COMMUNITY SERVICES DEPARTMENT

May 25, 2022

Subject: Grandview Reserve Filing No. 1 PUD Preliminary Plan, Review #3 – (PUDSP-21-010)

## Landscape Plan Enlargement

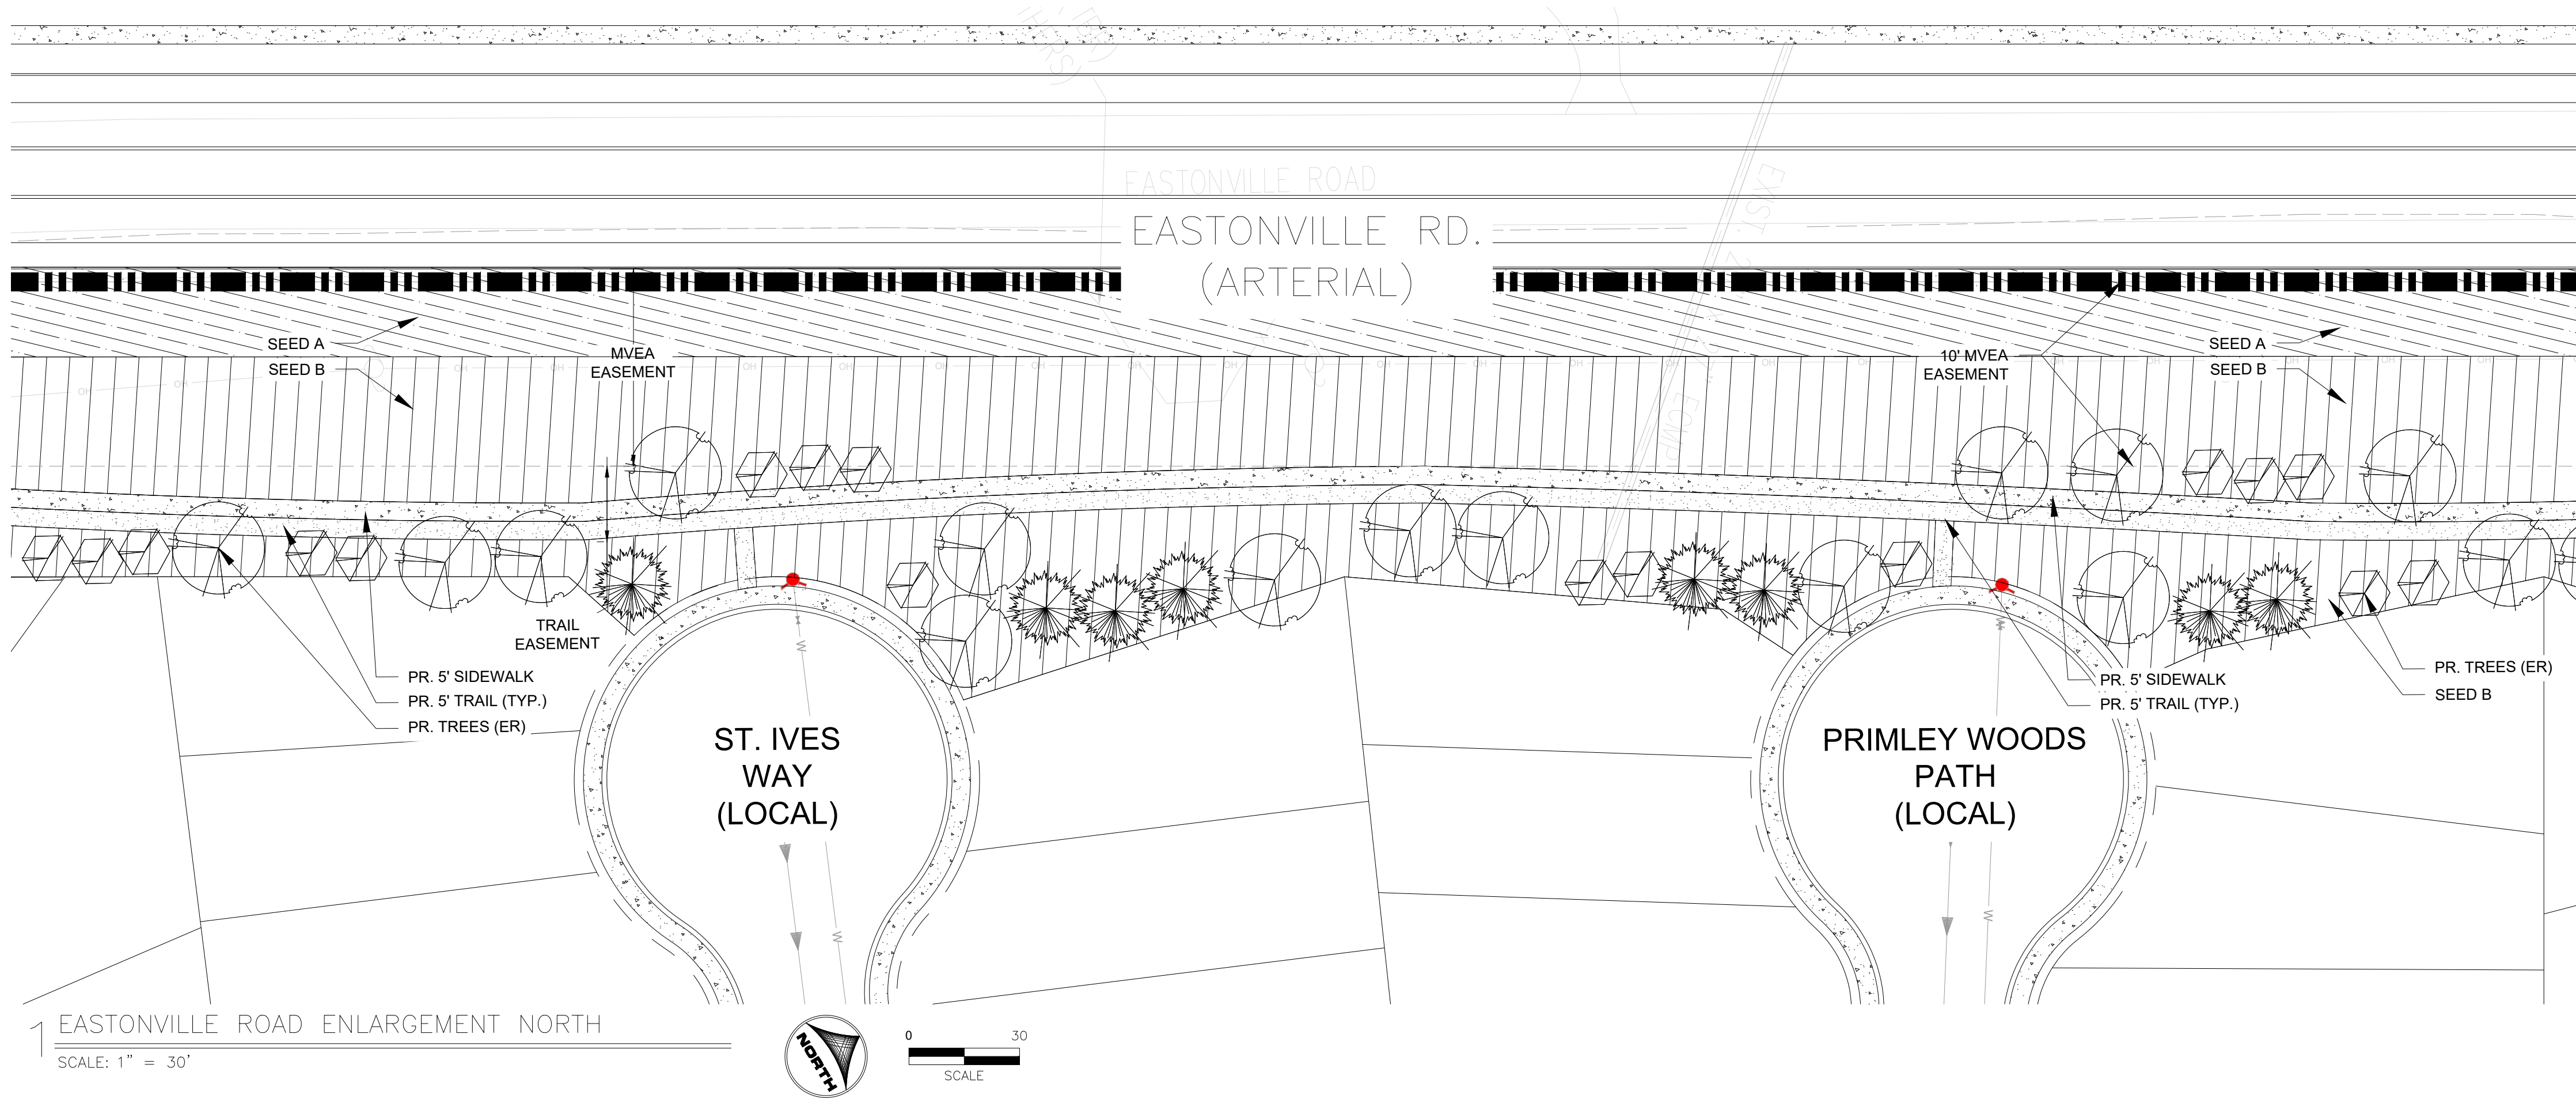
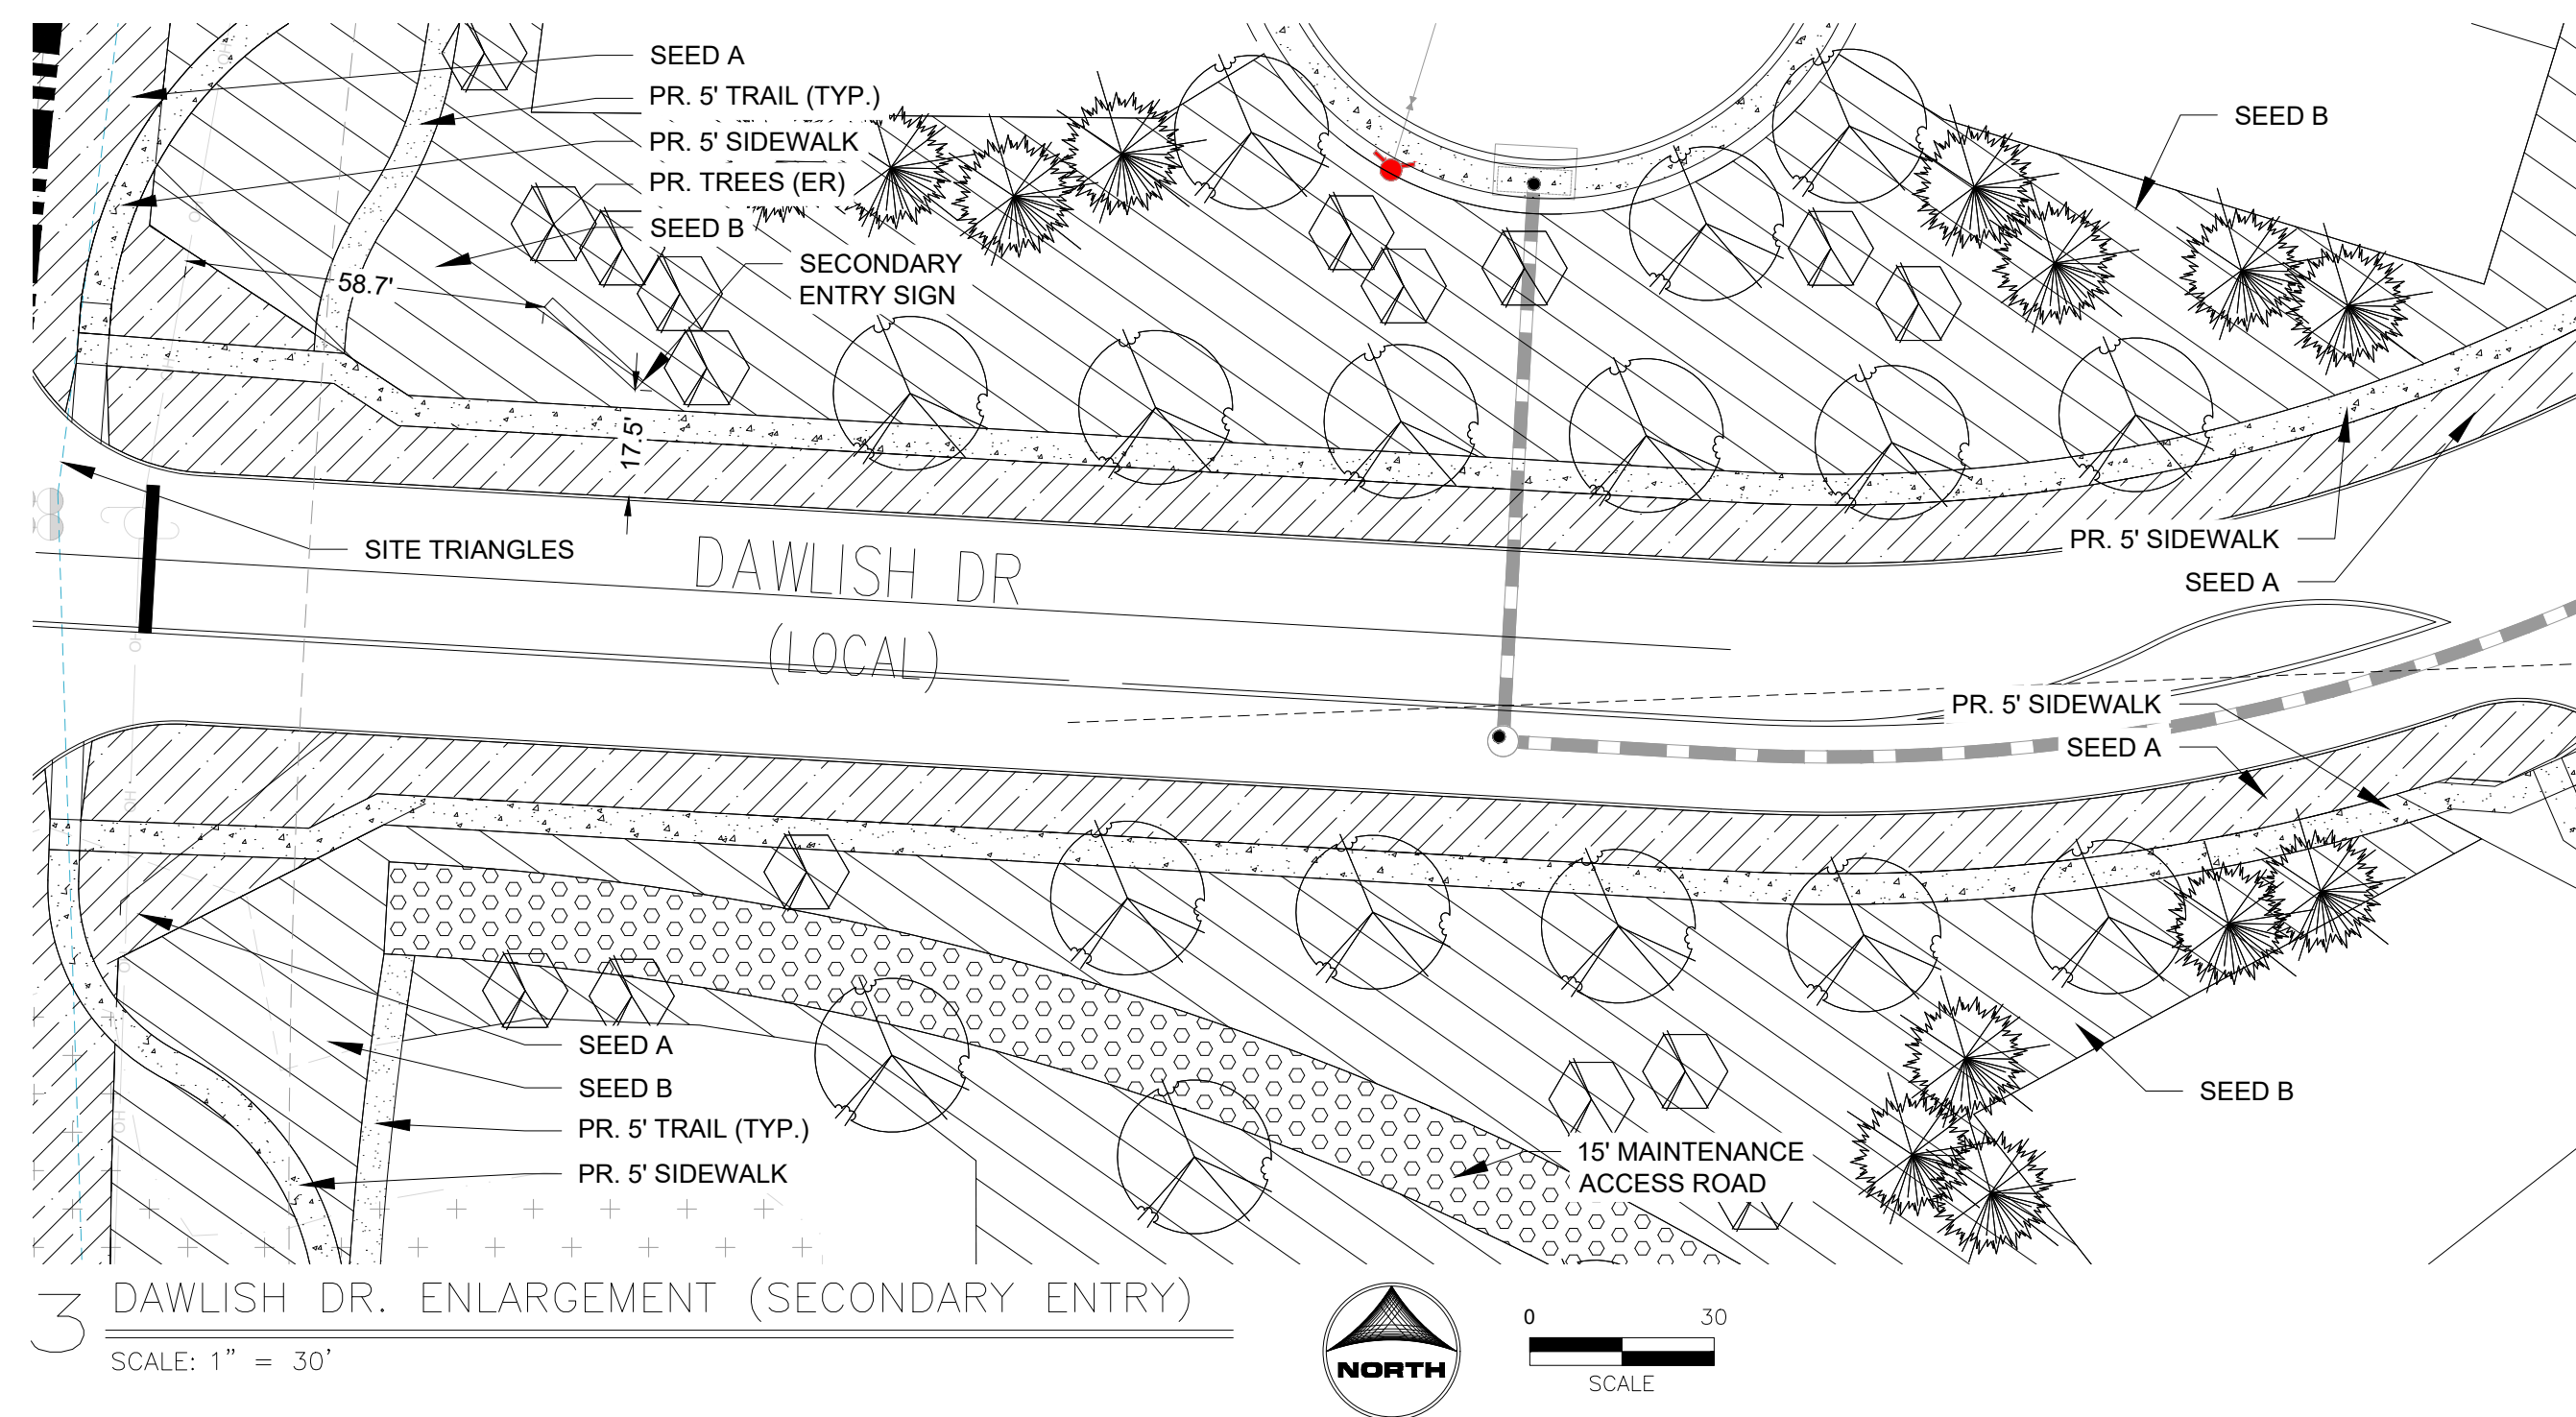
"Staff acknowledges and appreciates the inclusion of the detailed Amenity Center plans and Eastonville Primary Regional Trail easement as part of the Landscape Plans. Staff recommends that the trail easement be included and labeled in the PUD Development and Preliminary Plans, as is the case with other utility easements and right-of-ways along Eastonville Road. Please note the inclusion of an updated parks, trails, and open space map in this packet, which includes updated trails that have been revised as part of the ongoing 2022 El Paso County Parks Master Plan process."

Moreover, staff recommends that the applicant submit detailed site plans for the proposed Amenity Center, as the currently proposed neighborhood pocket park does not include multi-generational recreational amenities such as a playground, multi-use turf field, or seating and picnic areas. The submitted Landscape Plans only show landscaping and a connecting pathway within the proposed pocket park.
